CITY OF ALBUQUERQUE

November 14, 2014

**Re: McDonald's at San Mateo and Academy
Grading and Drainage Plan
Engineer's Stamp Date 11-5-14 (E18D019C)**

C7.0

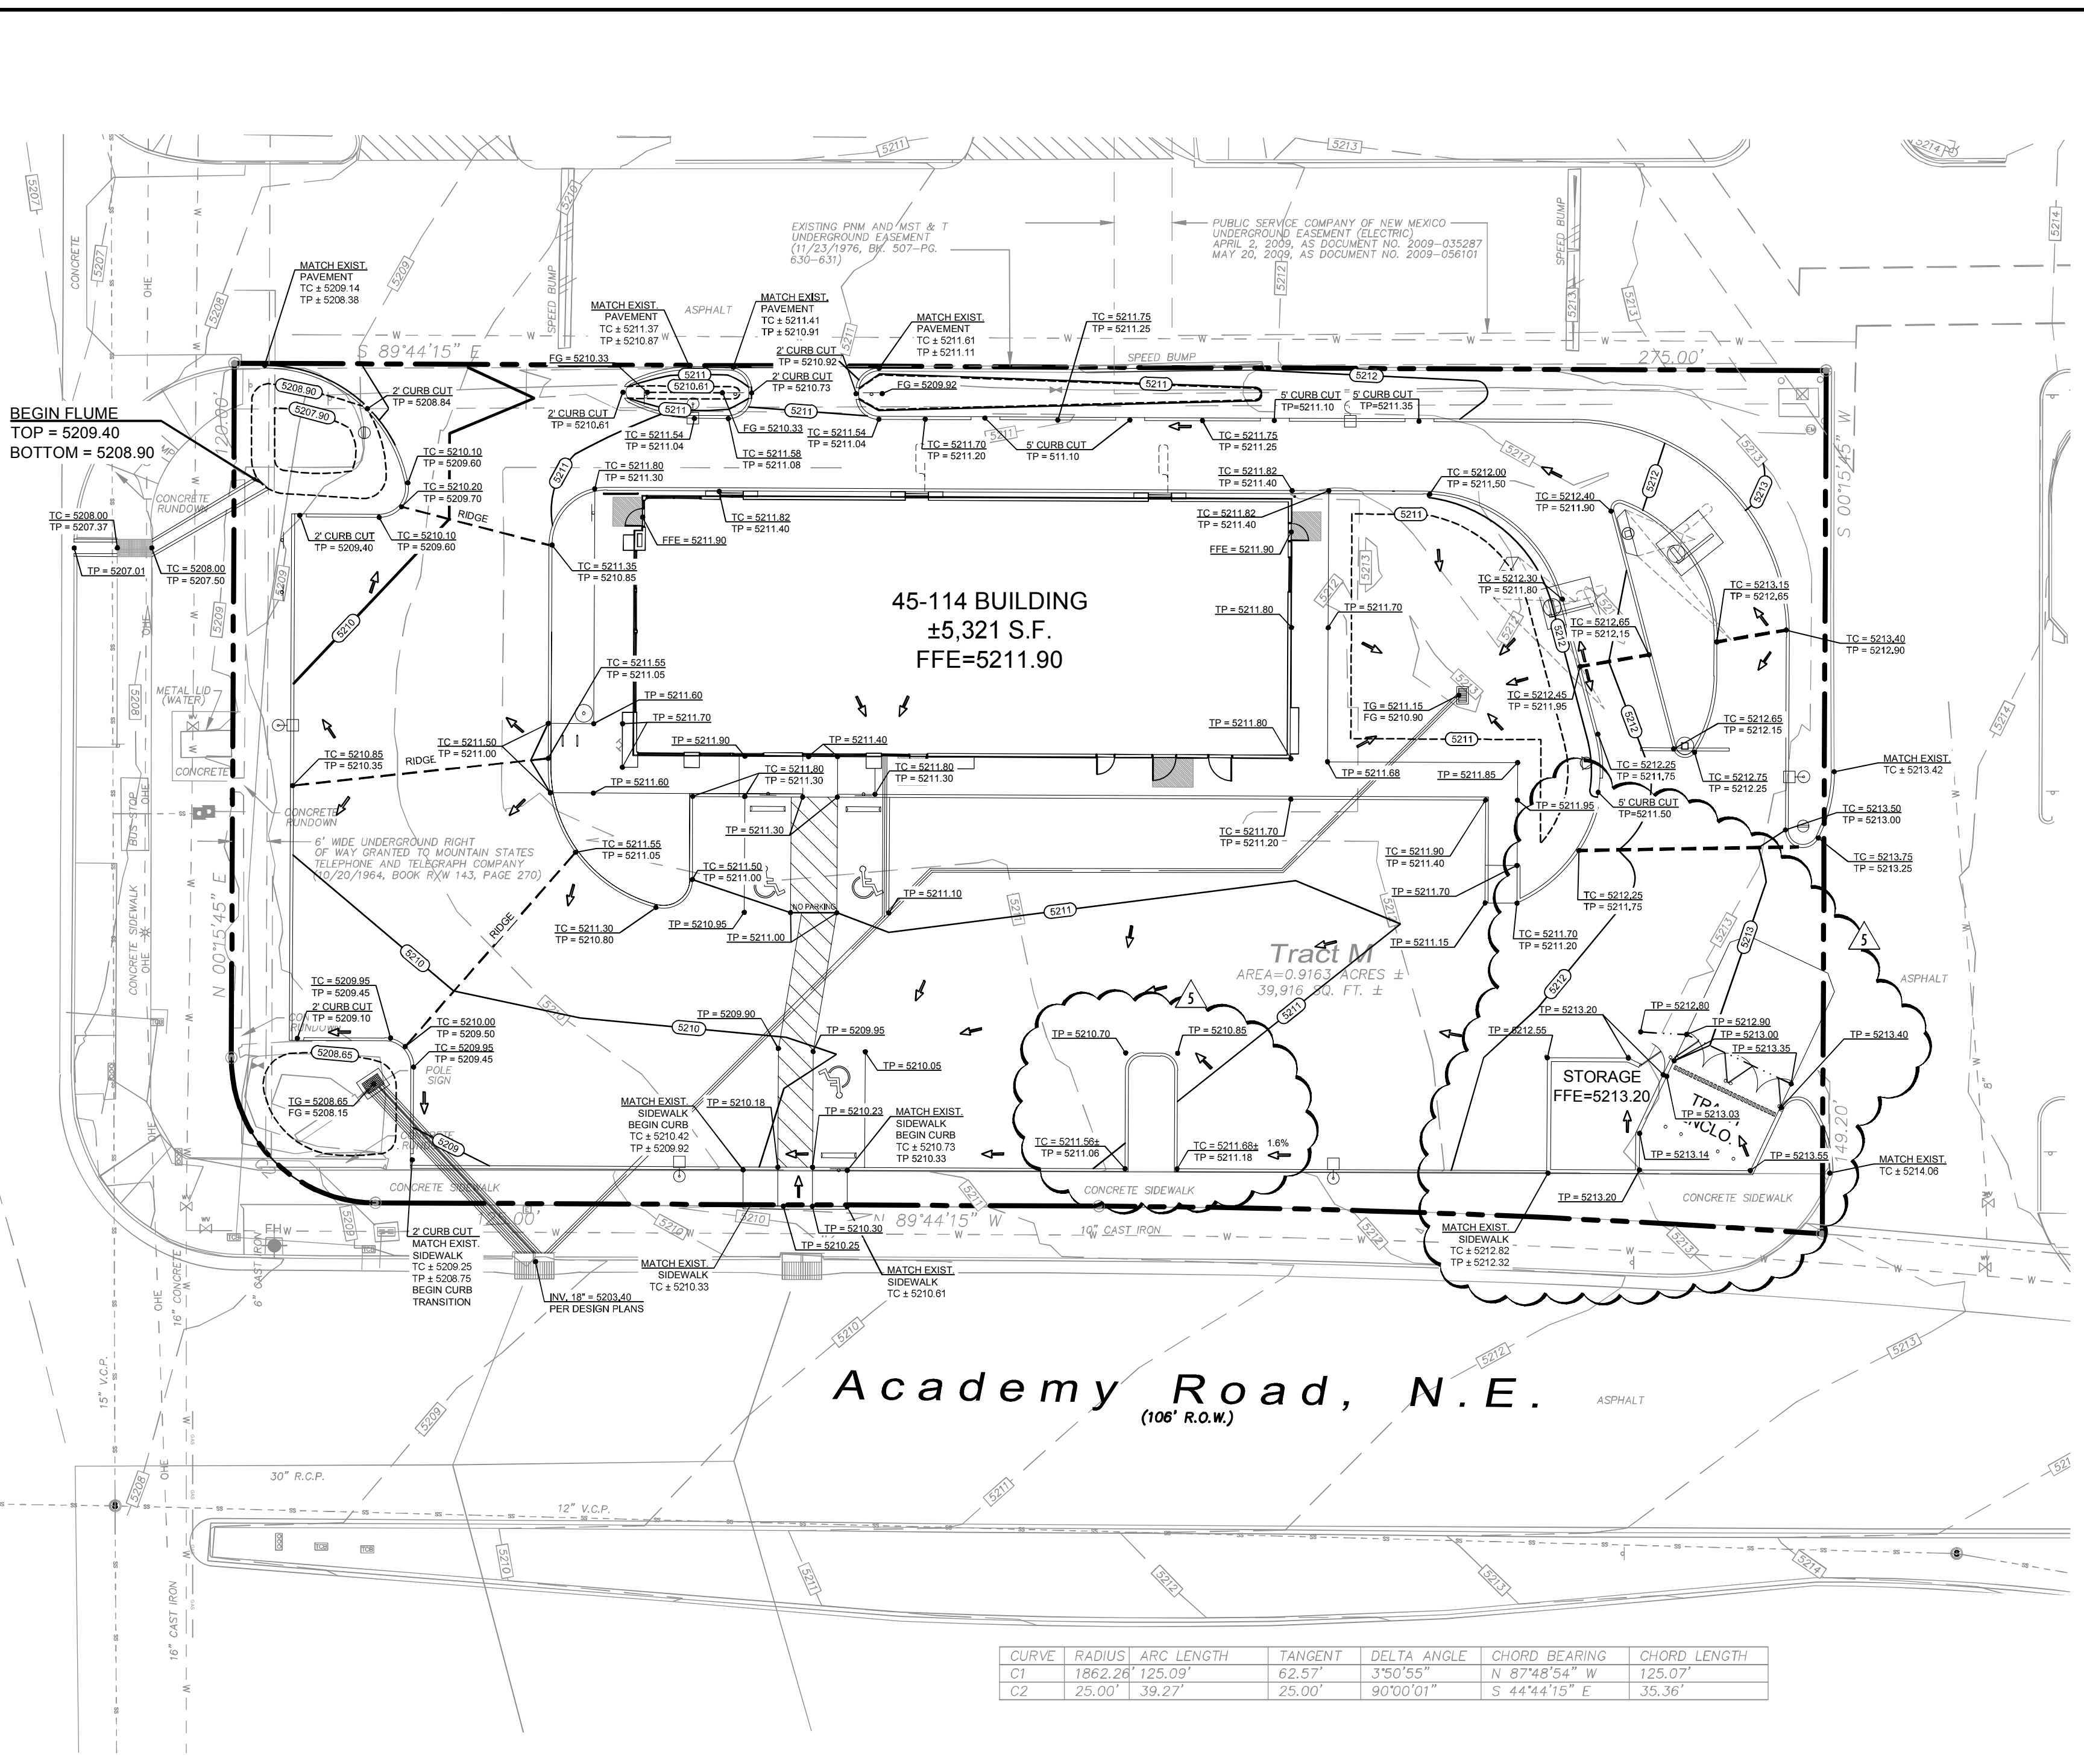
1. Check off Building Permit and SO-19 on the DTIS sheet.
2. Language for the SO-19 work is included on the plans, but the work is not called out for the new sidewalk culvert and rundown in the northwest corner, and for the sidewalk removal and replacement above the storm drain. Reference standard City details for this work in the Right-of-Way. For the Sidewalk Culvert, use the attached detail #2236 that was updated May 2011. Provide a detail for the flume / concrete rundown and include a width.
